From: Michael Eastham
Sent: 13 November 2017 20:36
To: Fiona Fitzgerald
Subject: FW: BE/102/17/OUT

Further to the comments/queries raised by the EHO, please see comments in red below and attached.

From: Fiona Fitzgerald
Sent: 08 November 2017 14:19
To: Planning.Responses
Cc: Michael Eastham
Subject: BE/102/17/OUT

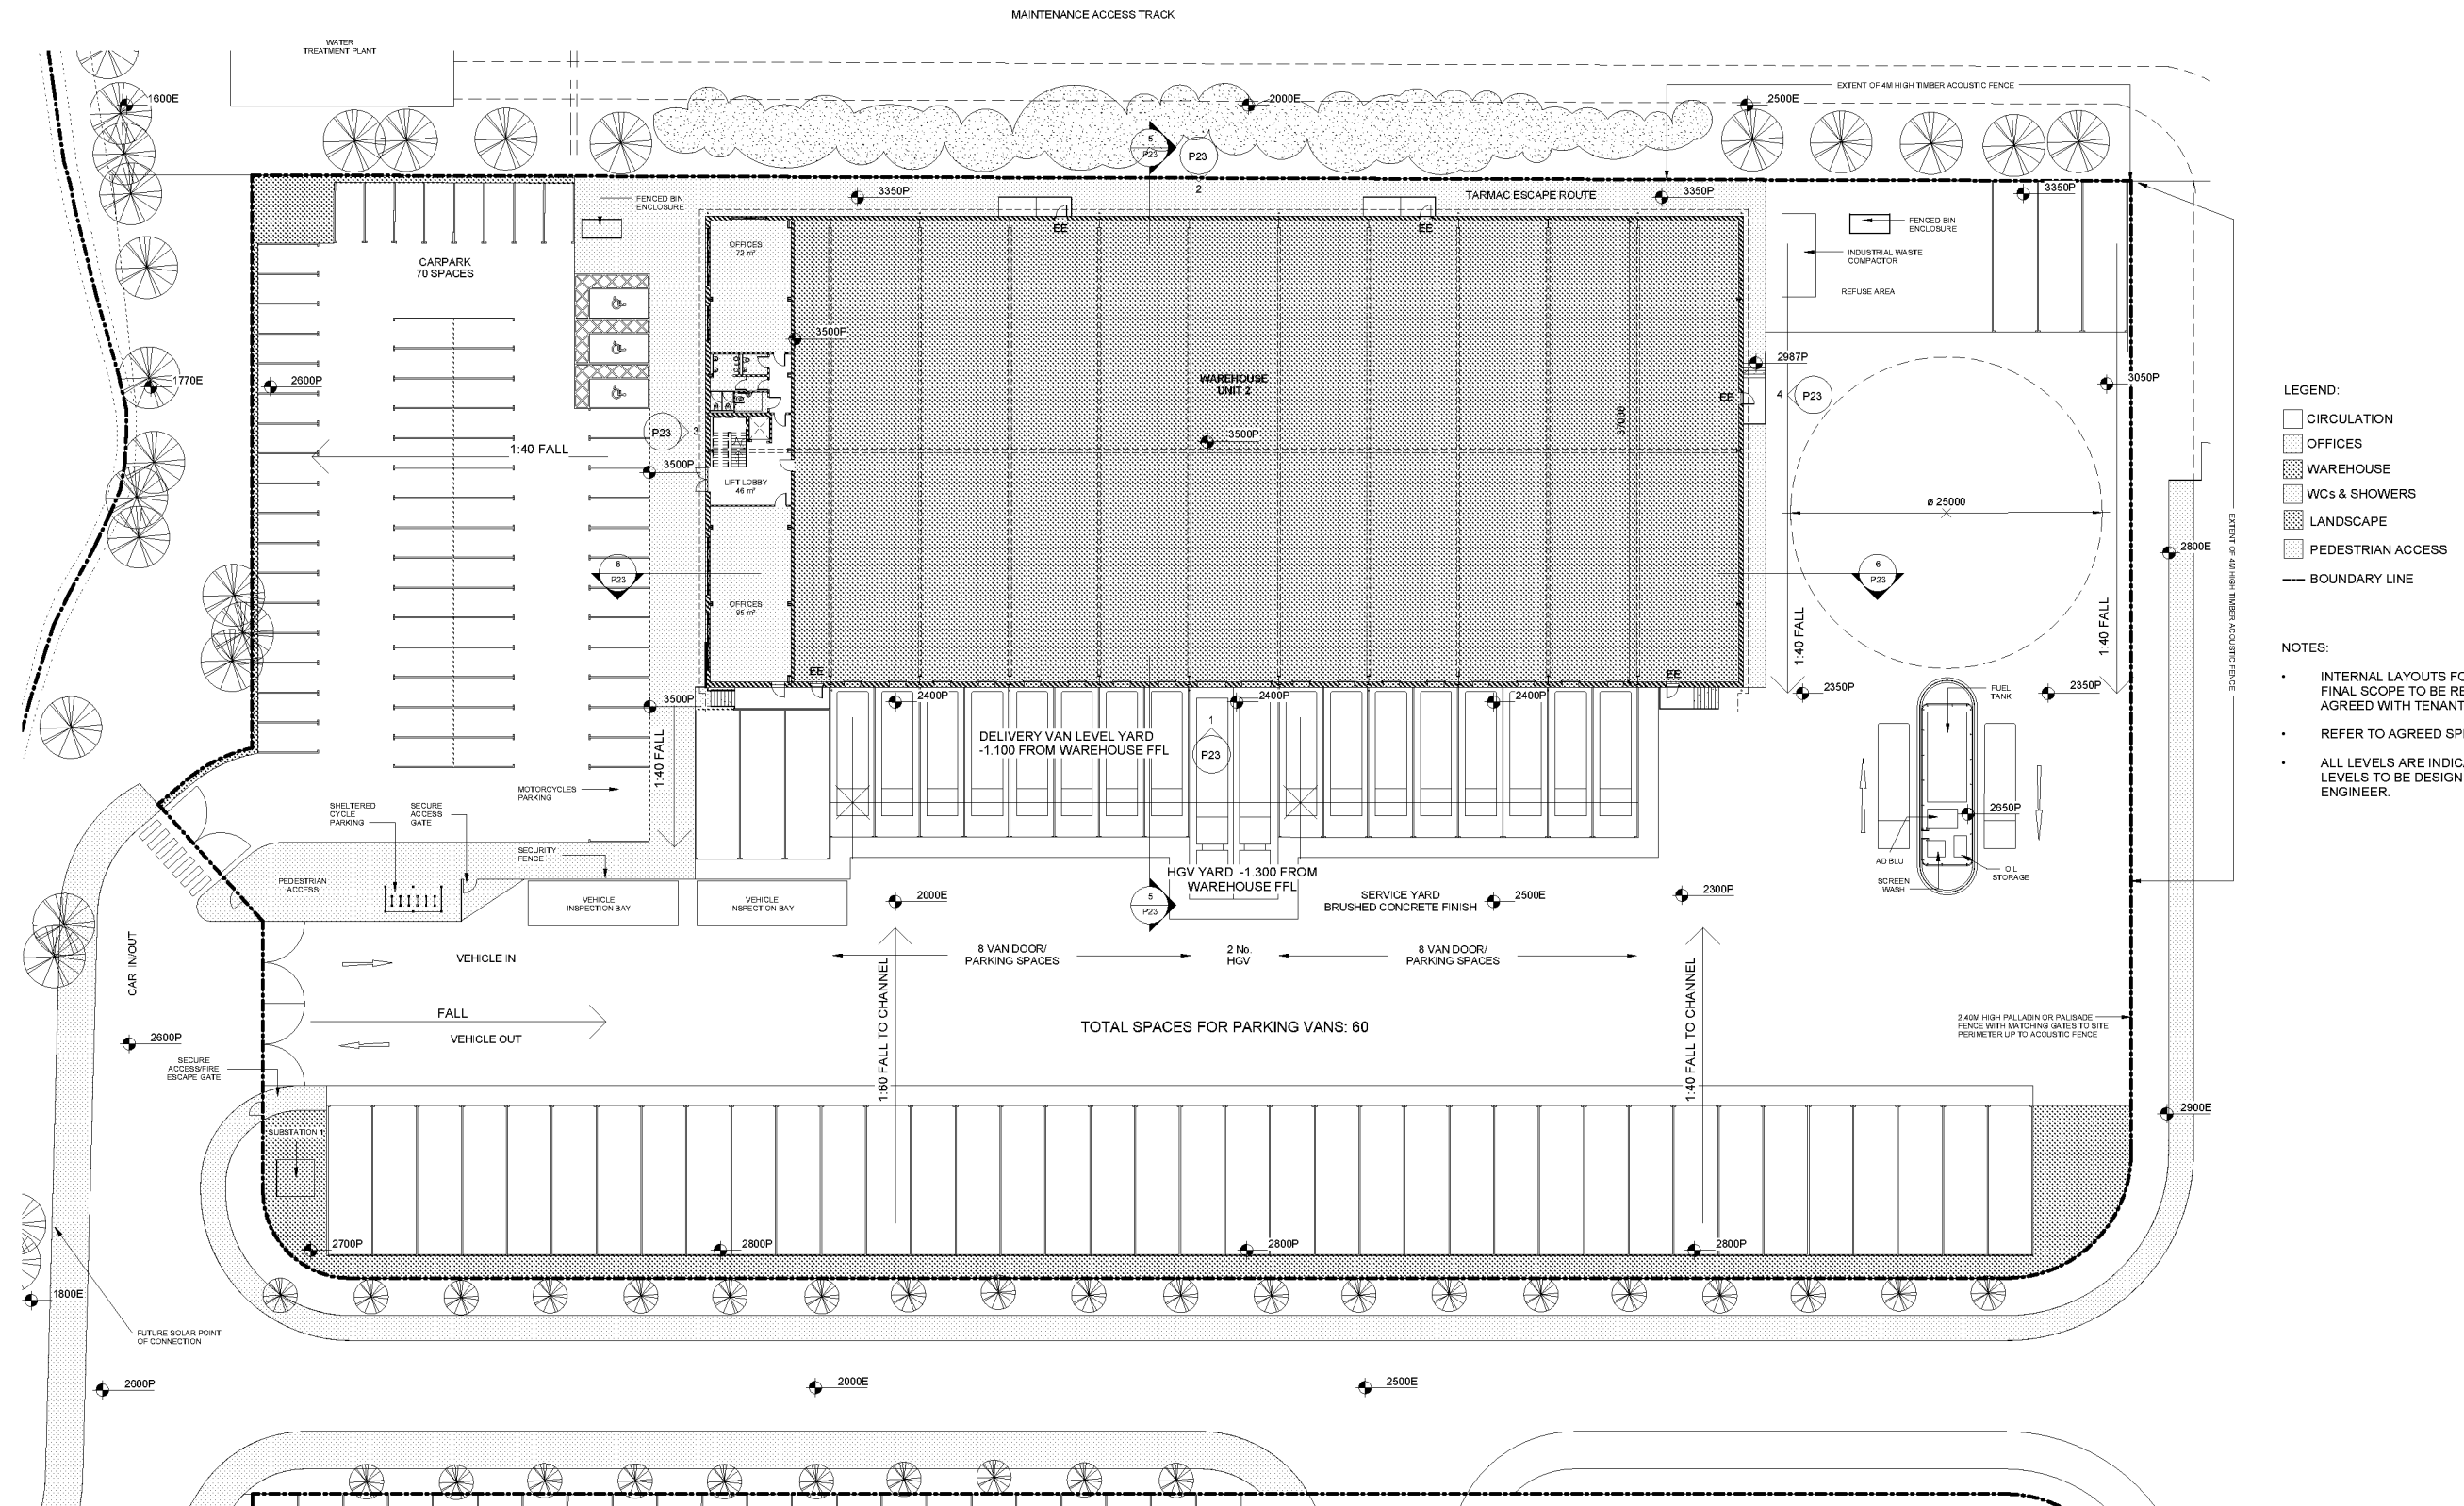
8. With regards to lighting please could the applicant give a justification for using zone E3 rather than zone E2?

9. Also with regard to lighting would the applicant consider using reduced coverage between 11 PM and 7 AM in line with the world health organisation guidelines? Although the WHO guidelines relate to noise it is considered that 11 PM to 7 AM is the night time, hence my question.

E2 covers rural , small villages or relatively dark urban areas.

E3 covers small town centres or urban locations.

If the preference is E2 this can be amended. Although I believe we are closer to a small town than a small village.

Please refer to item 1.6 within the external lighting statement. Lighting will be photocell/timedclock controlled. Times can be added/adjusted to suit.
